Appeal Decision

Appeal Ref: APP/Z4718/W/24/3358237

4, The Lodge, Paul Lane, Flockton Moor, Wakefield WF4 4BP

- The appeal is made under section 78 of the Town and Country Planning Act 1990 (as amended) against a refusal to grant planning permission.
 - The appeal is made by Mr Bob Kershaw against the decision of Kirklees Metropolitan Council.
 - The application Ref is 2024/62/91585/E.
 - The development proposed is a single storey side extension and change of use of land.
-

Block Plan as Proposed

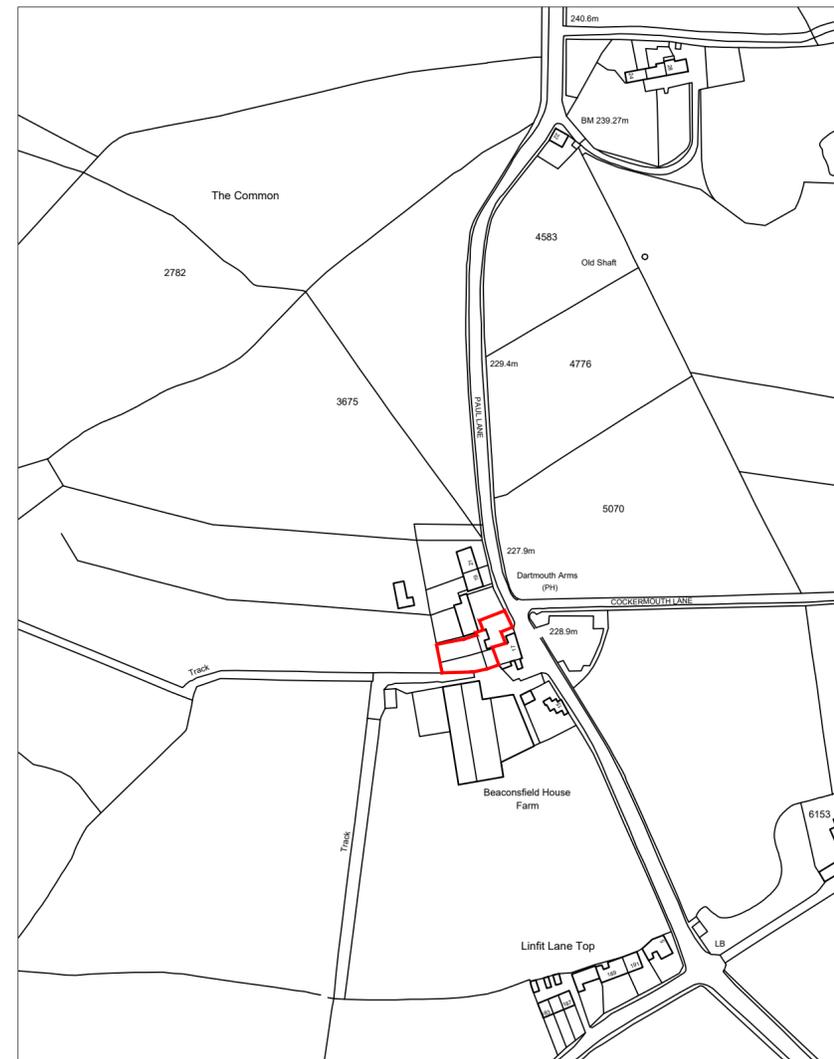
9. Although the existing area of agricultural land has been used as an area of hardstanding there are no buildings on this land and therefore it remains visually open in character. The openness of the agricultural land would be harmed by the more intensive use of the site as part of the domestic curtilage, including parking and domestic outdoor paraphernalia. Therefore, the change of use of the land would comprise inappropriate development in the Green Belt and cause moderate harm to its visual openness.

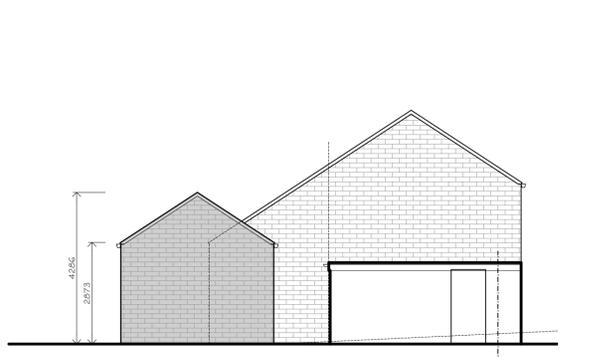
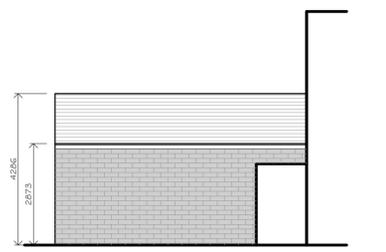
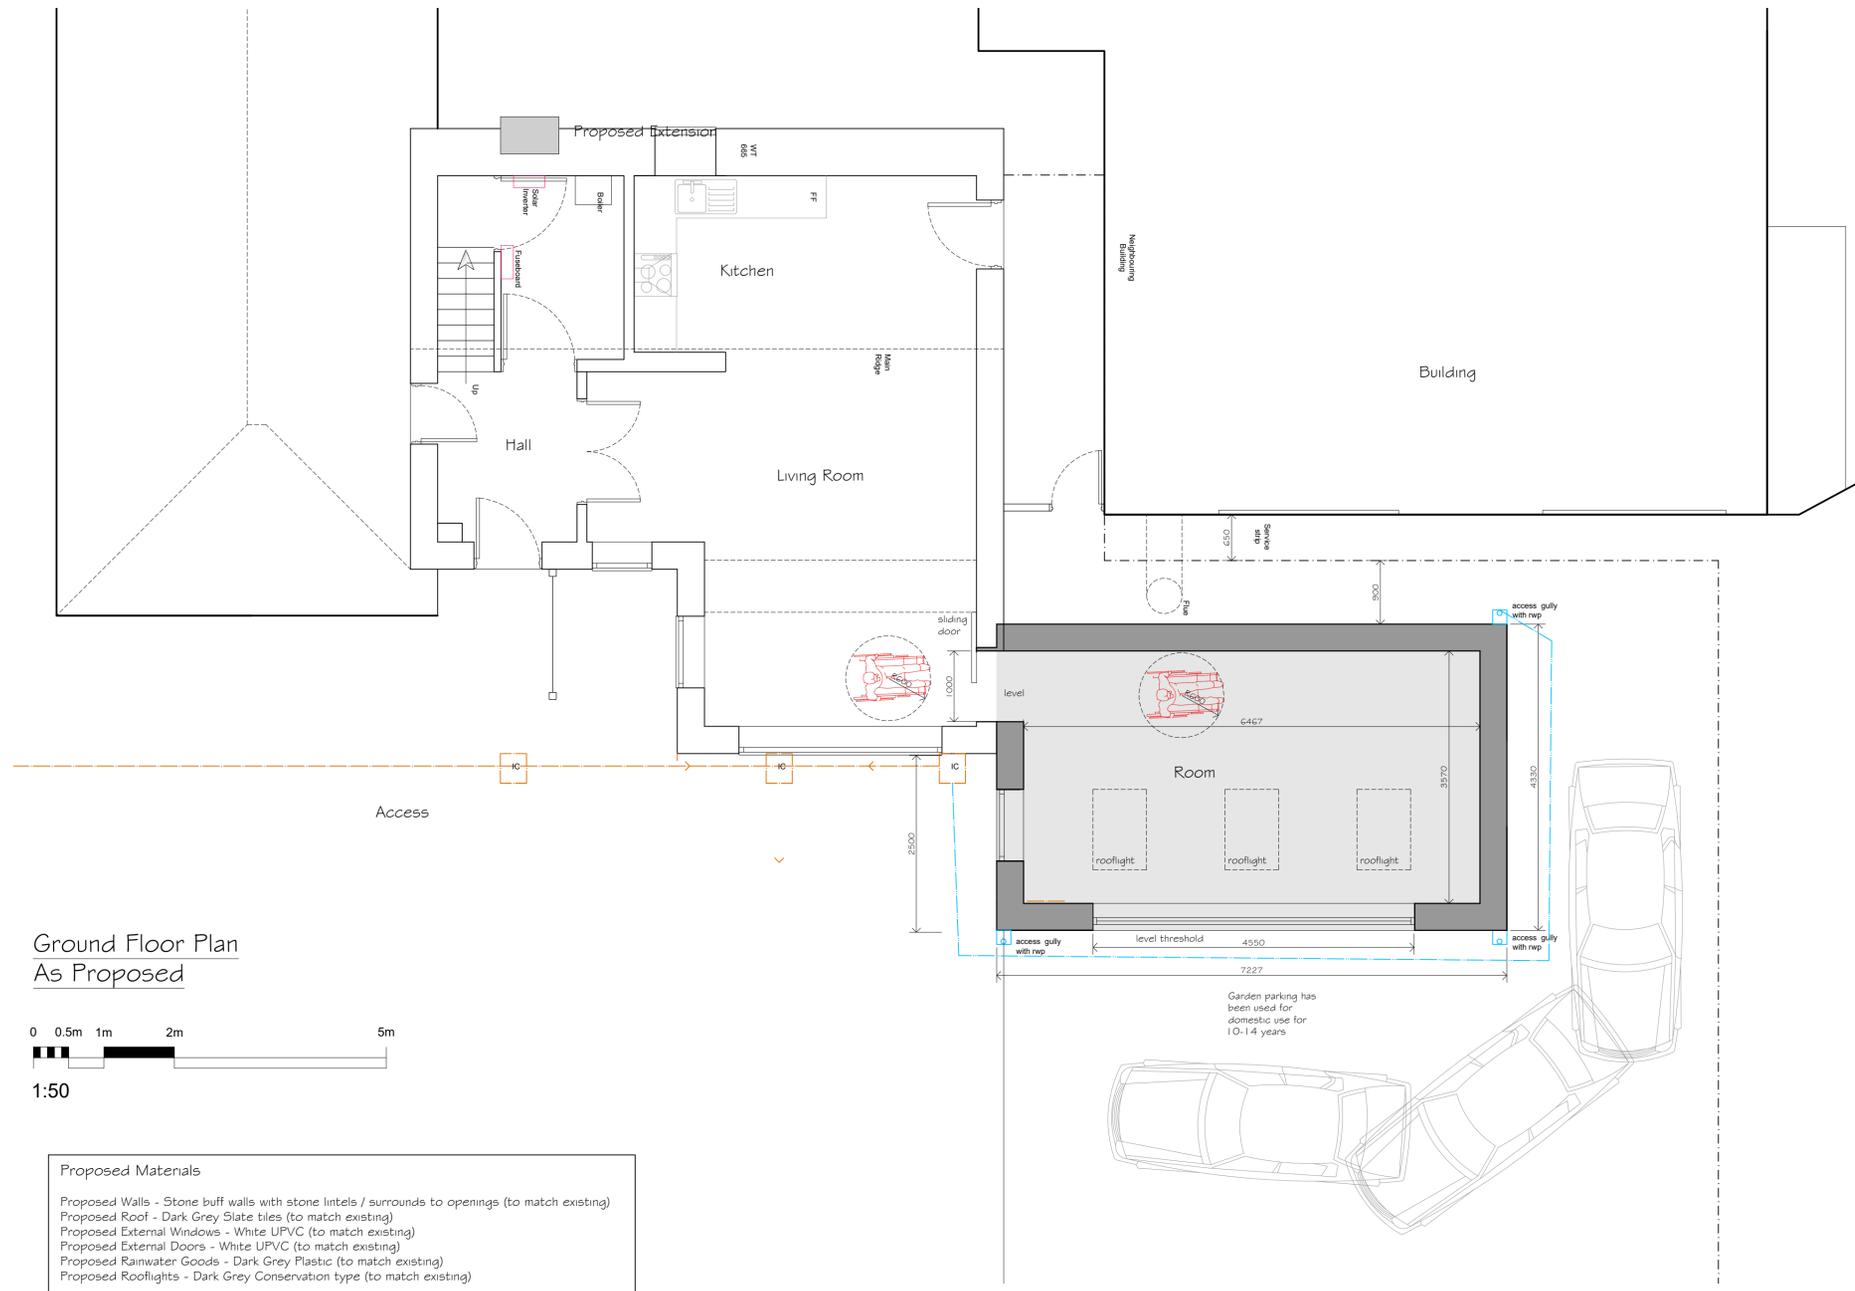
8. The proposed extension would have external dimensions of approximately 7.2m x 4.3m and a ridge height of approximately 4.3m. The Framework states that the definition of the original building is as it existed on 1 July 1948. Whilst I note that the dwelling was converted to this use in 2005, the original building was already extended as part of the 2005 development. The overall floorspace of the proposed extension would thereby be considerable in comparison with the existing footprint of the original building. Furthermore, as the extension would be set to the side of the host property, on existing agricultural land, it would extend well beyond the existing footprint creating a sprawled form of development and encroaching into the countryside. Therefore, due to its position, stretched form and scale, the proposed extension amounts to a substantial addition, and one I find to be disproportionate over and above the size and form of the original building. Thereby, the proposed extension is inappropriate development in the Green Belt.

14. The ridge height of the proposed extension would be lower than that of the host property, however it would have a similar height to the catslide extension element. Although the pitched roof of the proposed extension would follow a similar angle due to its offset position from the side and rear elevations of the host property it would read as a separate building. The side elevation of the proposal would be much wider than the rear elevation of the existing extension and visually compete with its scale and form, which would be accentuated by its offset position. The proposal would therefore dominate the appearance of the rear of the host property, thereby harming its character and appearance.

15. The existing dwelling was extended as part of its conversion and therefore it already has a stepped rear elevation. The proposed extension would project beyond this extension creating a further stepped effect to its rear, which would appear at odds with the existing built form of the wider group of buildings. Moreover, the extension would be located approximately 1.5 m from the rear elevation of the restaurant building, which would leave a long, narrow gap between the buildings resulting in an awkward visual relationship between the host building and restaurant.

17. I observed that the restaurant is not currently in use and appears to have been recently refurbished. The long thin, window on the rear elevation of the property, shown on the submitted Design Statement, has been replaced with a larger window which faces onto the appeal site. The proposed extension would run directly in front of this window with a gap of approximately 1.5m between the two buildings.

18. At the time of my site visit the property was advertised as being available to let for office accommodation and restaurant/café premises. The height of the proposed extension would restrict outlook almost entirely from the ground floor window, which serves a kitchen area. The kitchen window provides the only outlook from this room. The proposal would therefore provide a poor working environment for future staff, which would harm the economic function of the business.
19. The proposal would harm the economic function of the neighbouring business. It thereby conflicts with Policy LP10 of the LP which amongst other things seeks to improve the economic performance of the rural economy through supporting the needs of small and medium sized enterprises.
